Our reference: EF15/9530, DOC15/508402-01
Contact: John Goodwin

SSD 7262 – WESTMEAD HOSPITAL – MULTI-STOREY CARPARK EIS

MIKE SHARPIN
A/Manager Metropolitan Infrastructure
Environment Protection Authority
Encl. Attachment A

MULTI-STOREY CARPARK

Figure 1 – Site Map

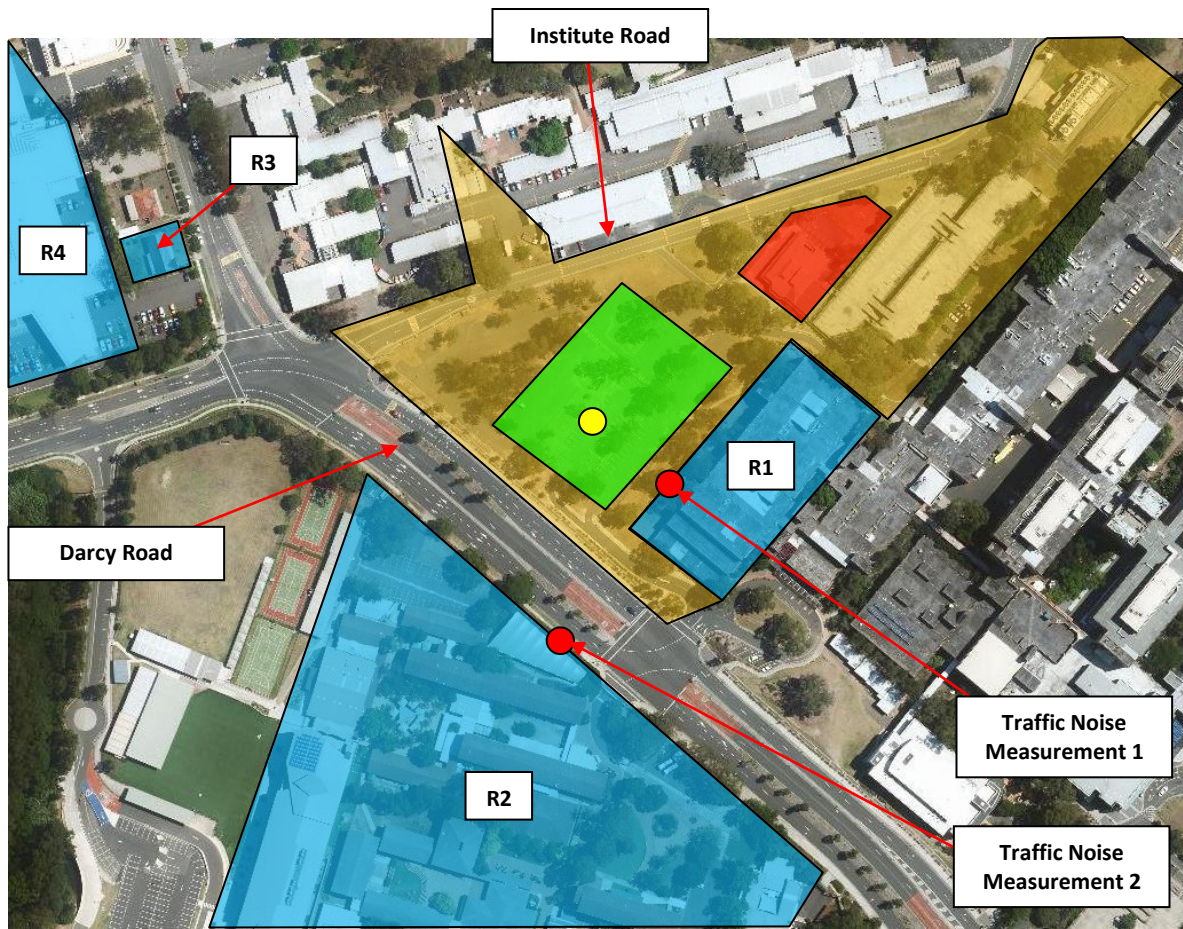
The EIS Noise Impact Assessment does not:

- (a) appear to assess construction noise impacts on either the private hospital or residences in Mons Street; and
- (b) indicate proposed construction hours.

EIS Appendix Q indicates that the proposed car park will be 8 storeys high and operate 24 hours per day 7 days per week. The EPA notes the location of residences in Mons Road and the proximity of Westmead private hospital. However, the EIS does not appear to provide an assessment of the predicted operational noise impacts (especially sleep disturbance impacts) on the nearby residences in Mons Road or on Westmead private hospital.

The proponent be required to revise the noise impact assessment of operation of the multi-storey parking structure to include a detailed noise impact assessment of –

- (a) potential sleep disturbance impacts on surrounding residents, private hospital patients and child care facilities (if any);
- (b) the need to apply 'modifying factors' (see INP chapter 4) to noise monitoring data and associated noise impact assessment; and
- (c) the need to provide noise shielding to minimise noise impacts of noise sensitive receivers; and
- (d) the need to adopt management measures to minimise noise impacts, especially evening and night-time impacts on noise sensitive receivers.
